**Subject: Wilpinjong Coal Mine Mod 3 – Pit 8 Extension (SSD-6764) Modification Report –
Response to Submissions**

Detailed advice to DPHI Planning & Assessment regarding the Wilpinjong Coal Mine Pit 8 Extension Mod 3 - RTS

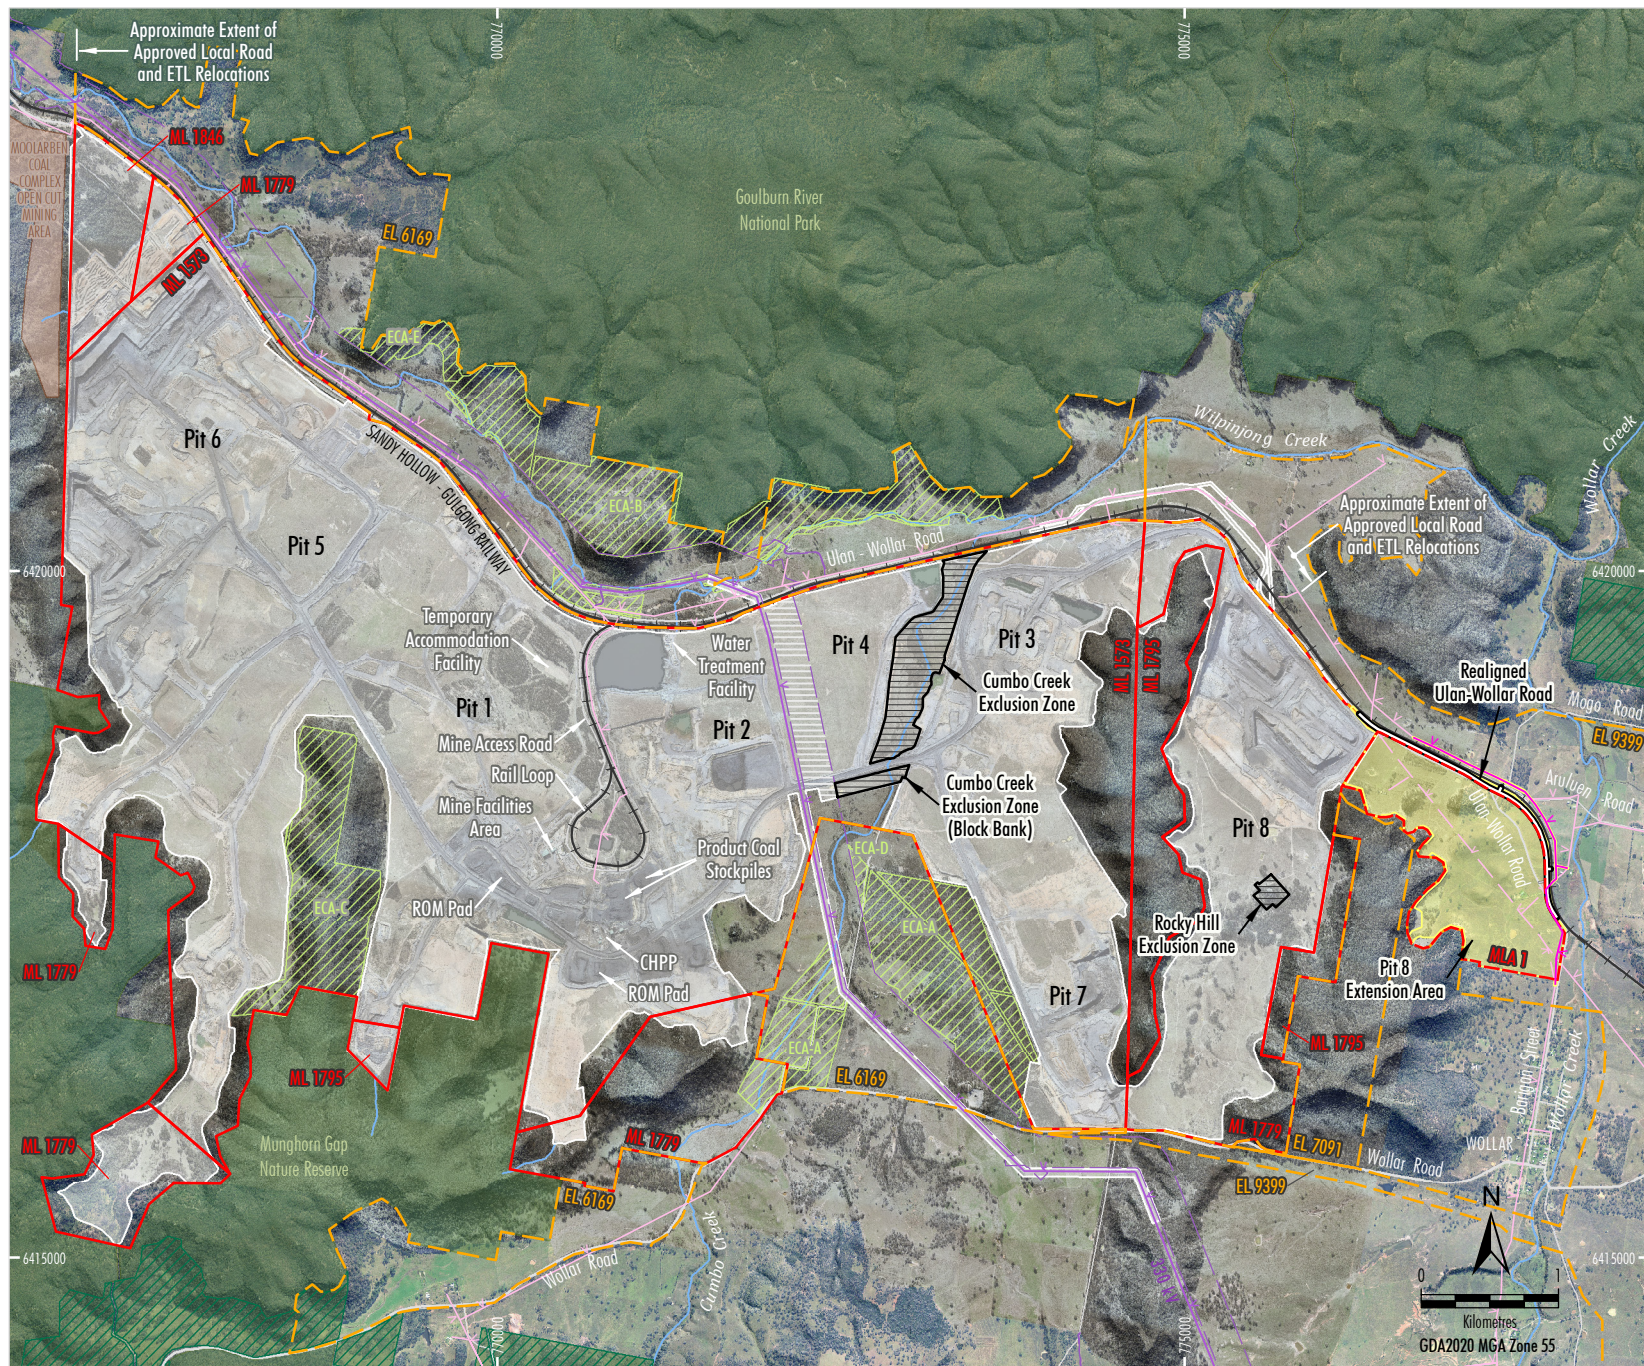
That Department of Planning, Housing and Infrastructure (DPHI) requests the proponent to amend the mining layout to include a 150m buffer between the expanded pit 8 and the highly productive alluvium of Wollar Creek.

As detailed in DCCEEW Water's response (OUT25/12927) submitted at the Modification Report stage, the combination of factors of high stream order, highly productive alluvium, groundwater dependent ecosystems and the potential for groundwater and surface water impacts arising from mining related connectivity justifies a precautionary approach. Wollar Creek is a 7th order watercourse with alluvial groundwater which is mapped as moderately to highly vulnerable. These characteristics align with the intent of defining the Schedule 3 streams in the DIPNR (2005) guideline and therefore it is considered appropriate to adopt the same considerations. It is recognised this approach extends beyond the general requirements of the NSW Aquifer Interference Policy, however the DCCEEW Water Group prefers a precautionary approach on this occasion and maintain its recommendation for a 150m buffer between open cut mining and the alluvial boundary.
